**WELWYN HATFIELD BOROUGH COUNCIL  
EXECUTIVE DIRECTOR - PLANNING, PUBLIC PROTECTION AND GOVERNANCE**

**DELEGATED APPLICATION**

**Application No:** 6/2017/2513/FULL  
**Location:** 33-34 Salisbury Square Hatfield AL9 5AF  
**Proposal:** Conversion of existing ground floor (Class A3) restaurant to form two (2xbed) flats (Class C3) including part demolition and extension at ground and first floor (rear) with associated external alterations.  
**Officer:** Mrs June Pagdin

**Recommendation:** Refused

**Drawing**  
**Site Plan**

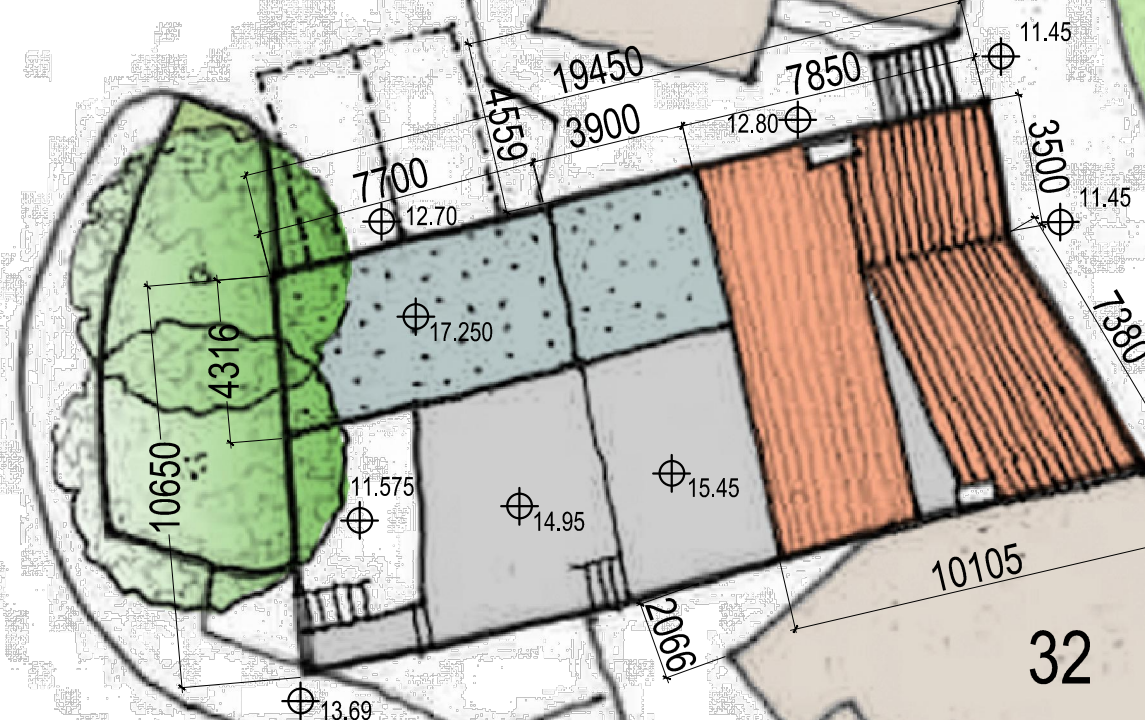
<p><b>Refuse and Recycling</b></p>	<p>The site layout plan shows no refuse/recycling stores within the site boundary. At present the restaurant wheelie bin appears to be stored on the pavement in the pedestrian passageway. The steep steps down to the rear yard and the lack of on-site provisions are a strong indication that refuse/recycling storage cannot be provided within the proposed development on the site. This is another indication that the proposal constitutes overdevelopment of the site.</p>
<p><b>Houses in Multiple Occupation</b></p>	<p>Since 12<sup>th</sup> January 2012, there has been an Article 4 Direction covering the whole of Hatfield removing permitted development rights for change of use from C3 (Dwellinghouse) to C4 (Houses in Multiple Occupation). The rationale</p>
